This comment refers to the National Highways Response to ExQ2, specifically the "Single Public Rights of Way and Access Plan (Appendix C of REP5-027)".

COMMENTS ON THE RIGHTS OF WAY PLAN

FIGURE 7
Existing and Proposed
Rights of Way

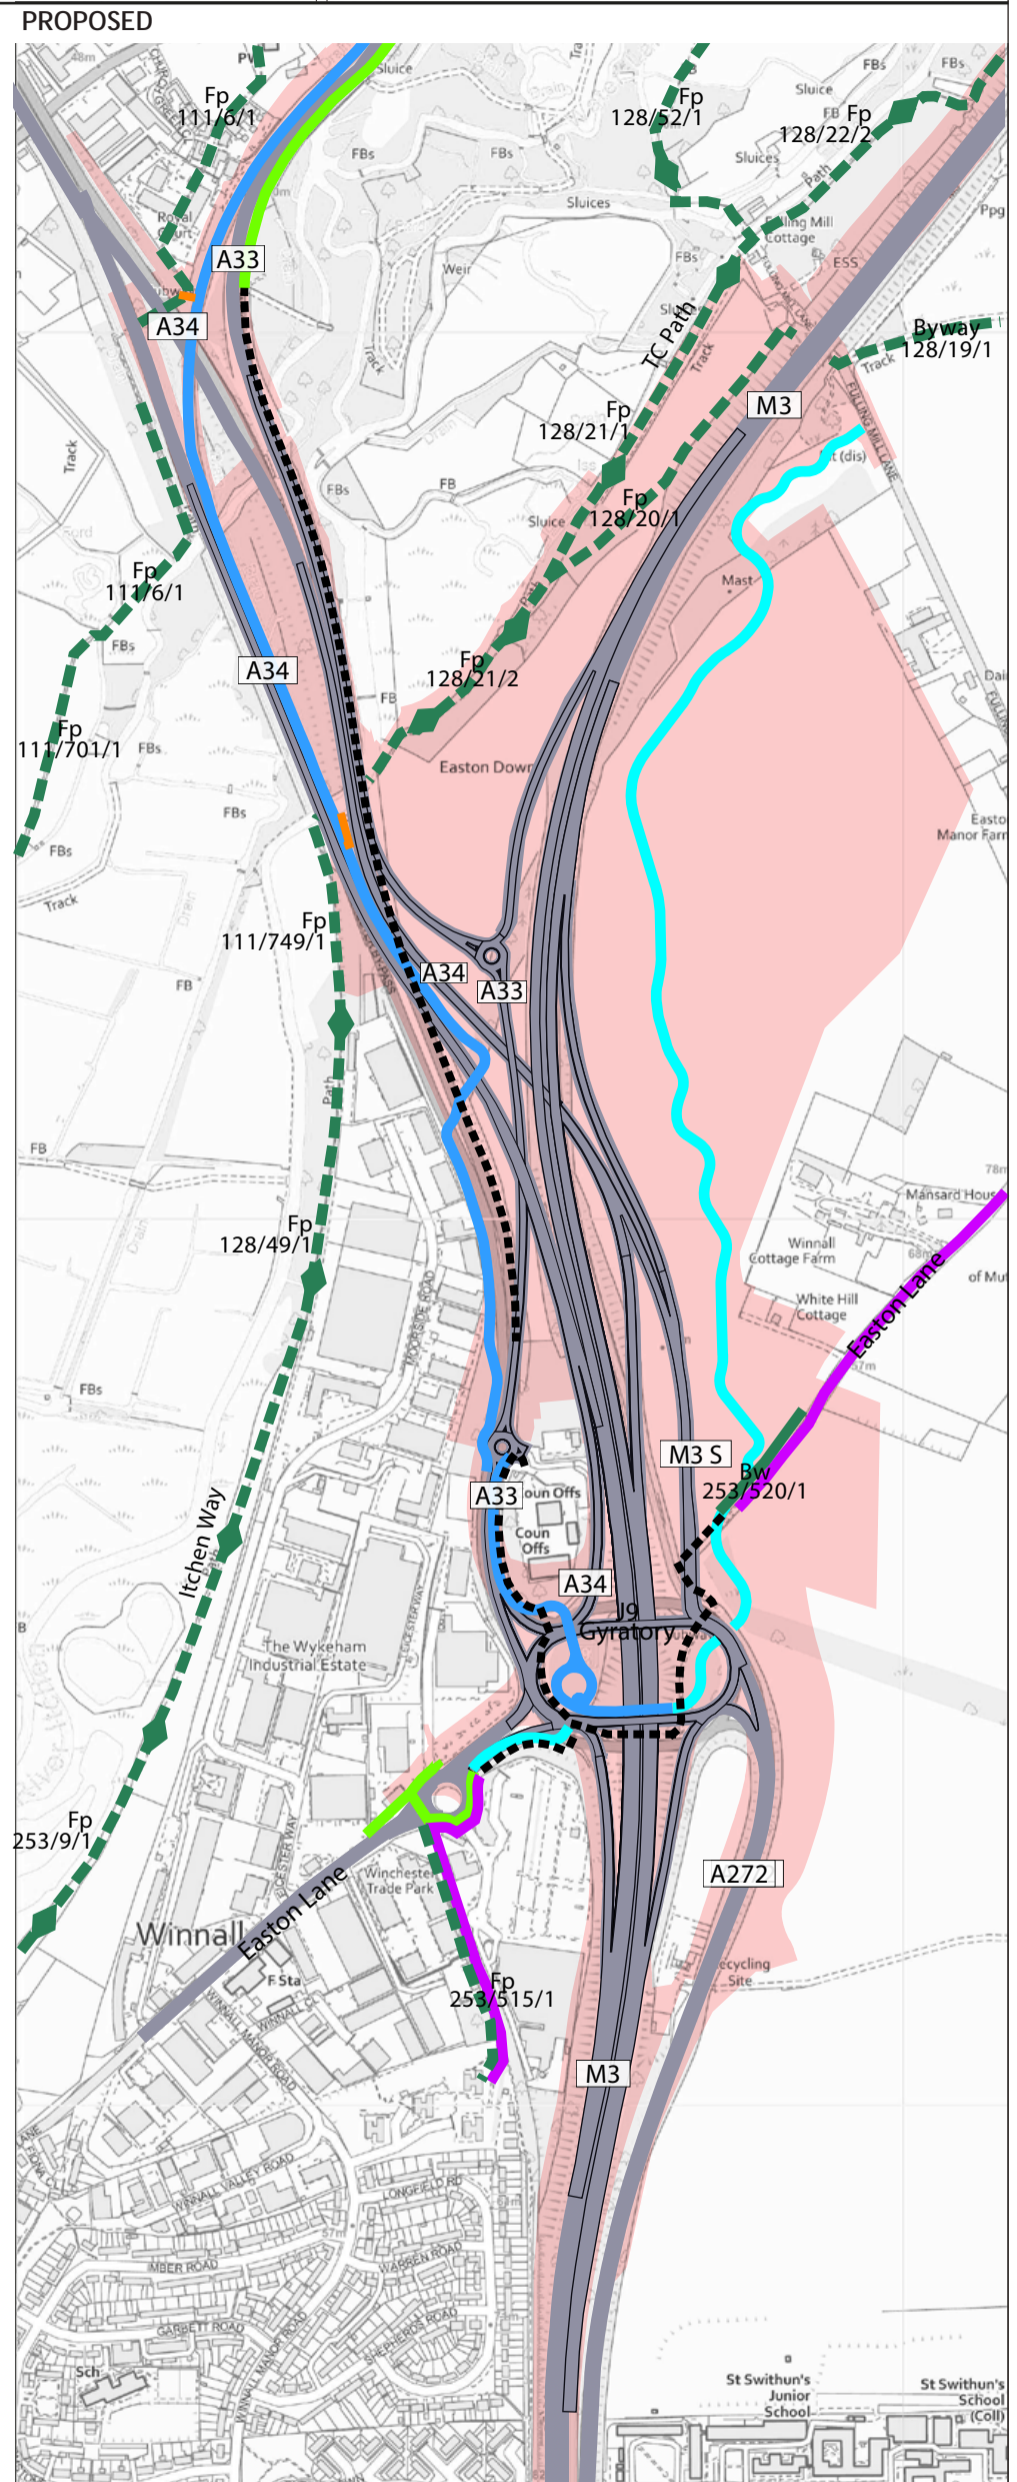
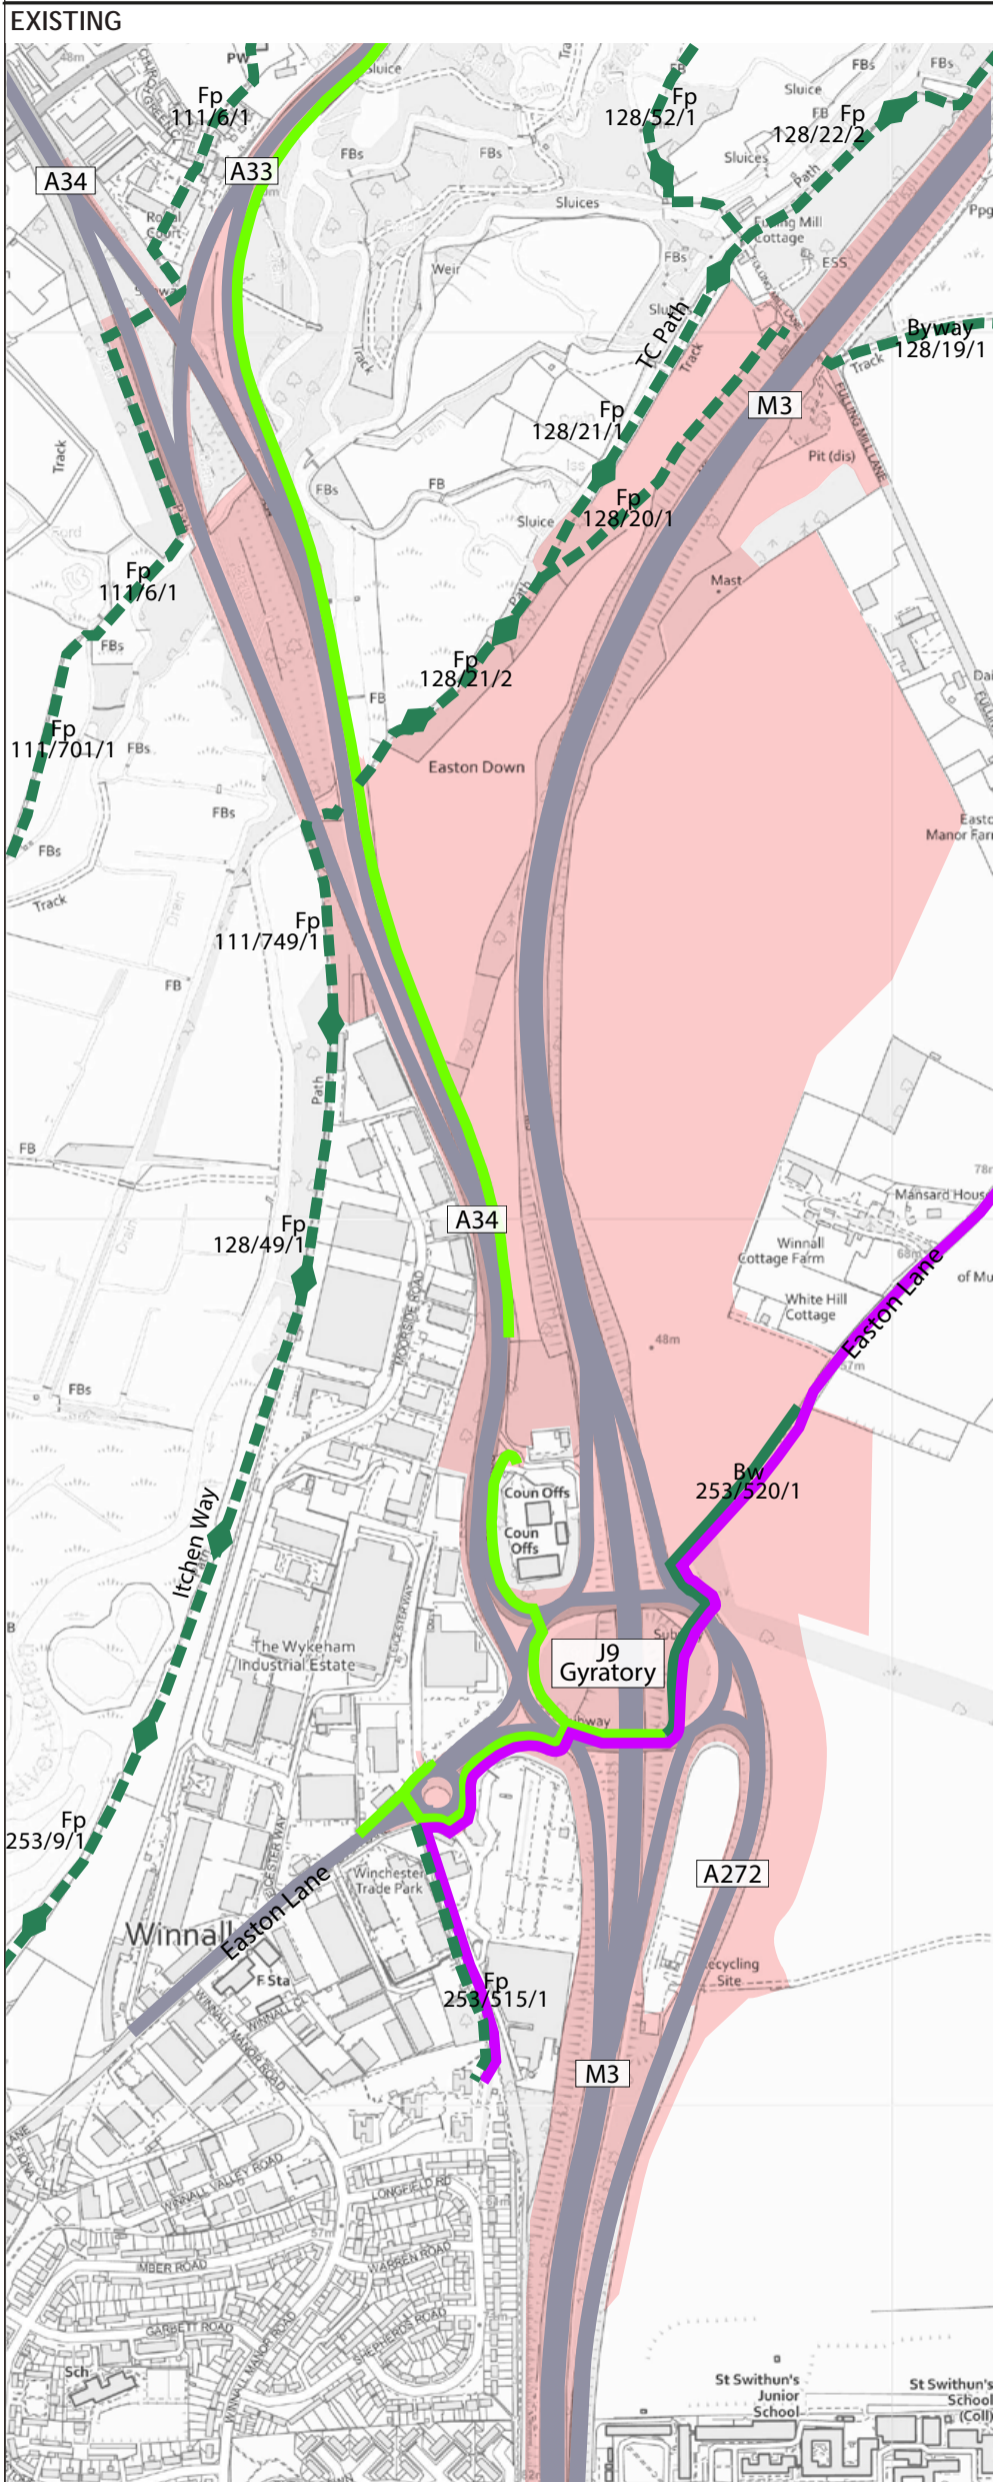
- (1) It once again highlights the failure to resolve the anomalous situation of a bridleway that goes part-way across the junction then stops at the overbridge.
- (2) It doesn't clarify the proposed diversion routes for the existing rights of way during construction.
- (3) The included Schedule table includes a "Proposed maintaining authority" column - the first time this information has been recorded publicly as far as we're aware. This shows an incoherent and disjointed patchwork of responsibility, with NH expecting Hampshire County Council to take on maintenance of most parts of the cycle route even within the boundaries of Junction 9.

We have attached a snapshot of the plan on which we have highlighted HCC-maintained sections in yellow, NH in red. The maintenance status of the cycle track on the overbridge above the motorway is ambiguous, but as the schedule stands it implies that this is HCC's responsibility.

This disjointed approach will lead to inconsistent path maintenance and quite probably to future arguments over who is responsible for what later on.

NH should bear in mind that it has a responsibility to all users of its facilities, not just to motorists, and take on maintenance for every part of the rights-of-way within the boundaries of the junction.
